Please ask for: Mrs D Johnson
Email: daun.johnson@arun.gov.uk
Telephone: 01903 737762
Our Ref: A/96/21/PL
Your Ref:
Date: 18th May 2021

Application for Planning Permission

Development: Installation of Portakabin building to be used as additional teaching area. This site is in CIL Zone 2 (Zero Rated) as other development.
Location: Worthing Rugby Club, Beech Tree Childcare Roundstone Lane Angmering BN16 4AX

Title
Proposed Block Plan

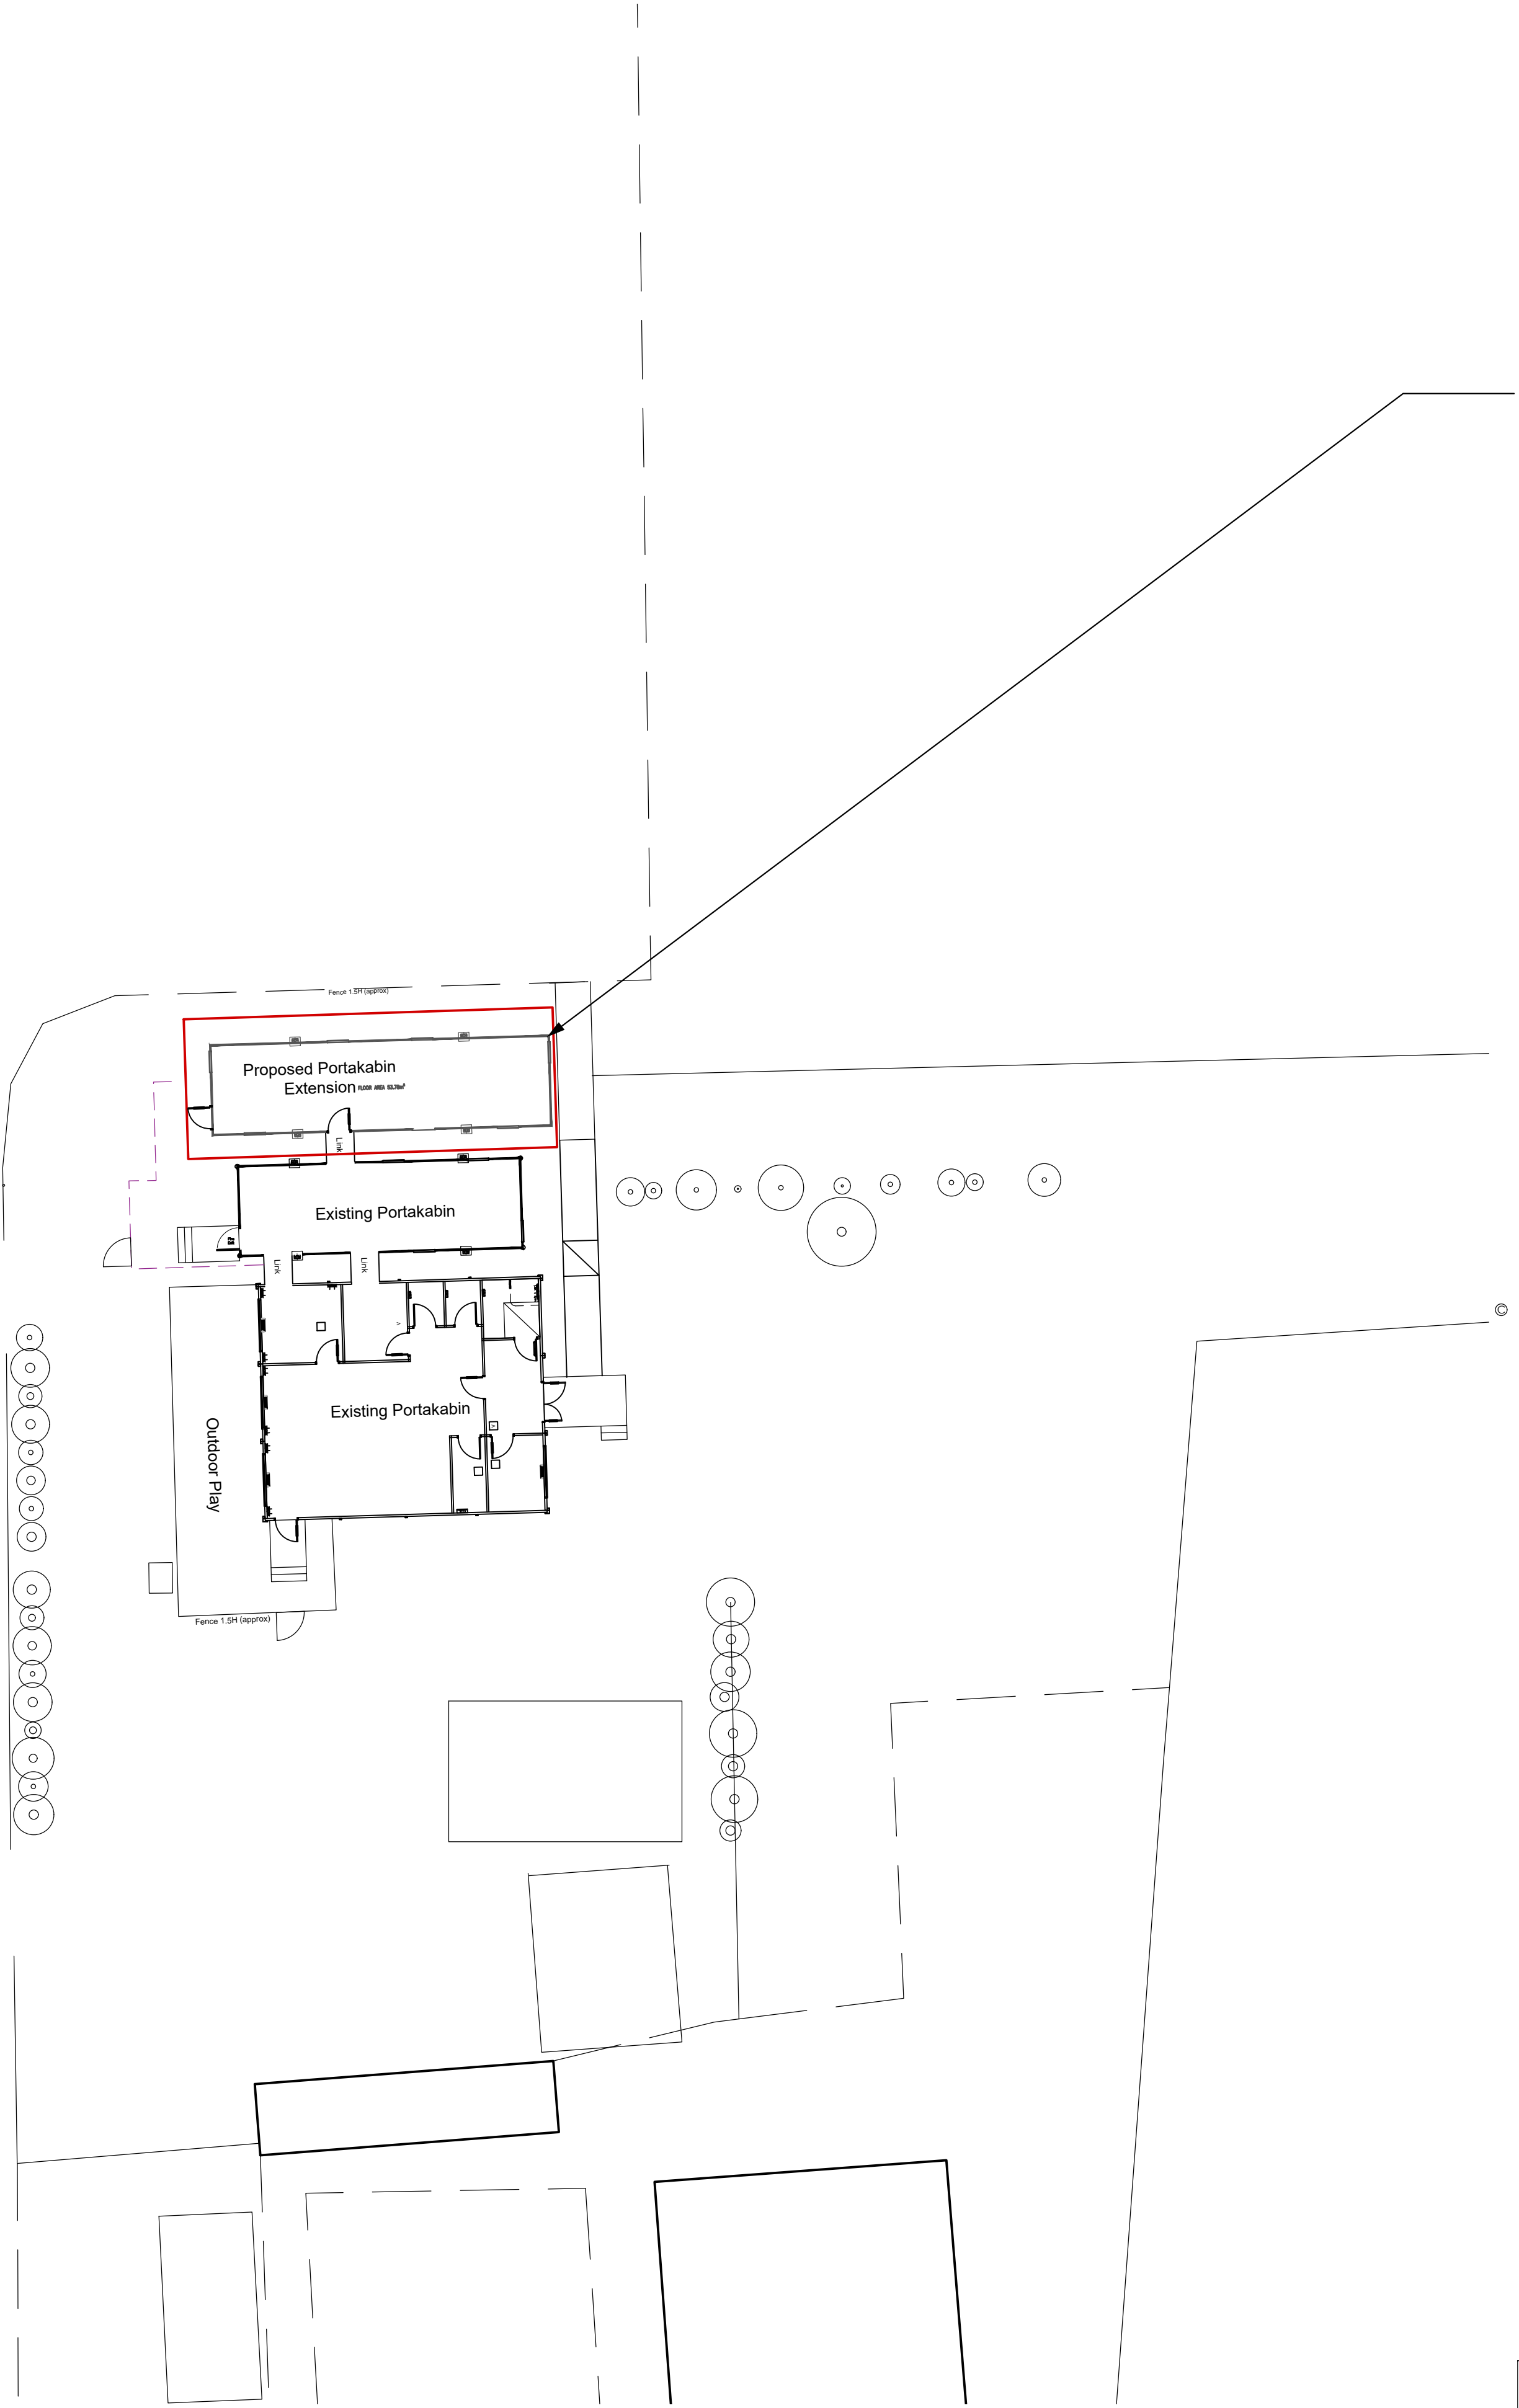
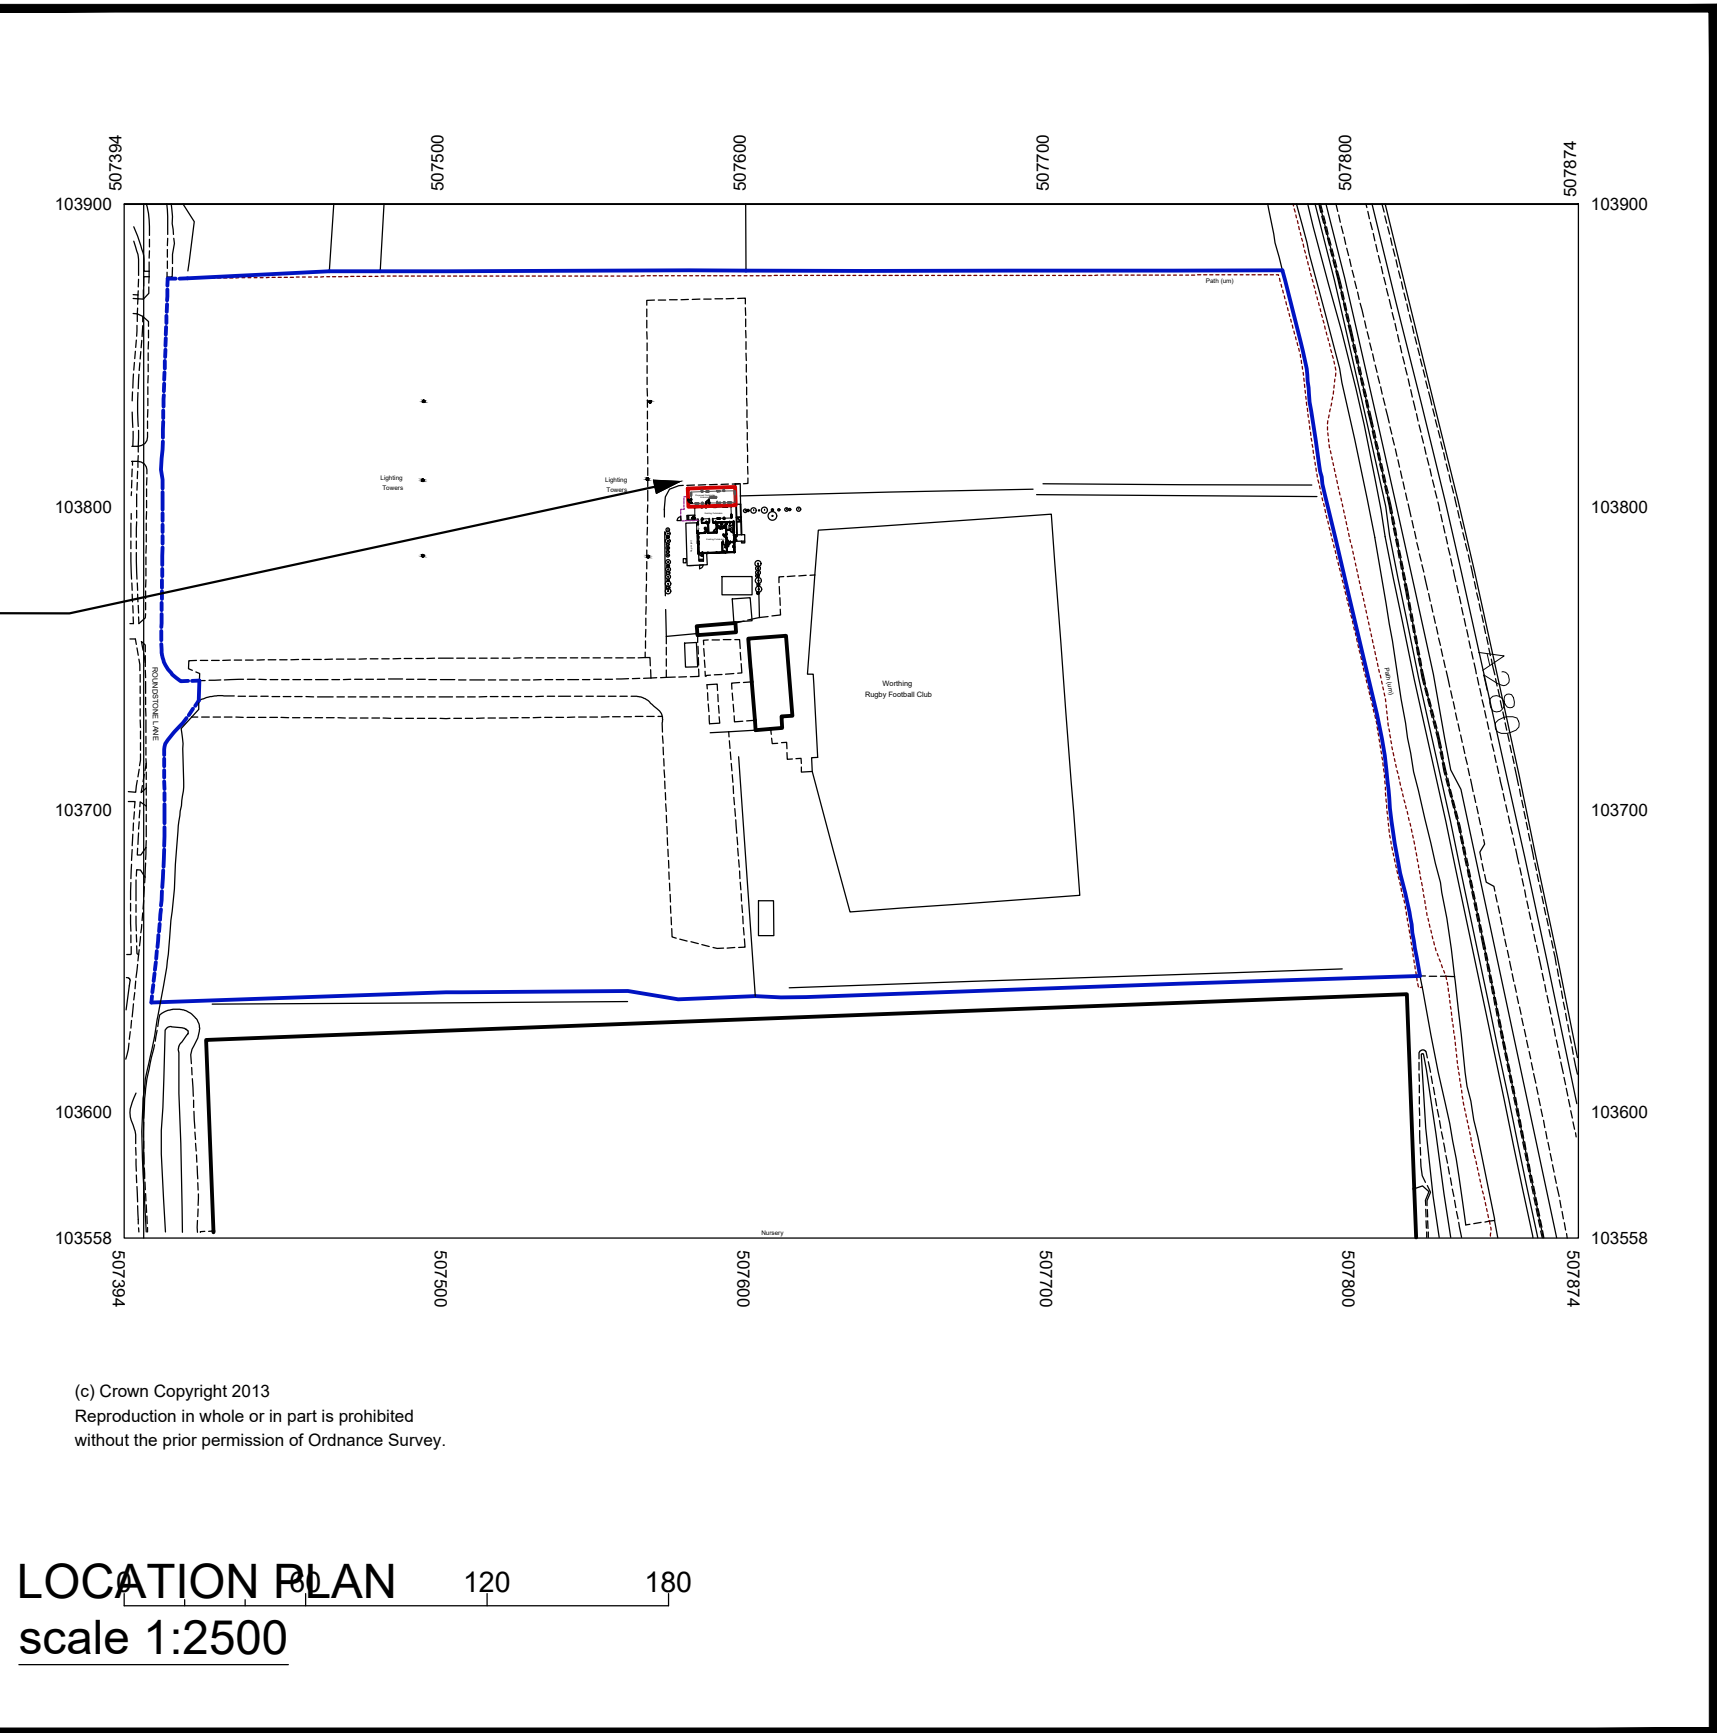
The location and block plans do not scale correctly. Please amend accordingly.
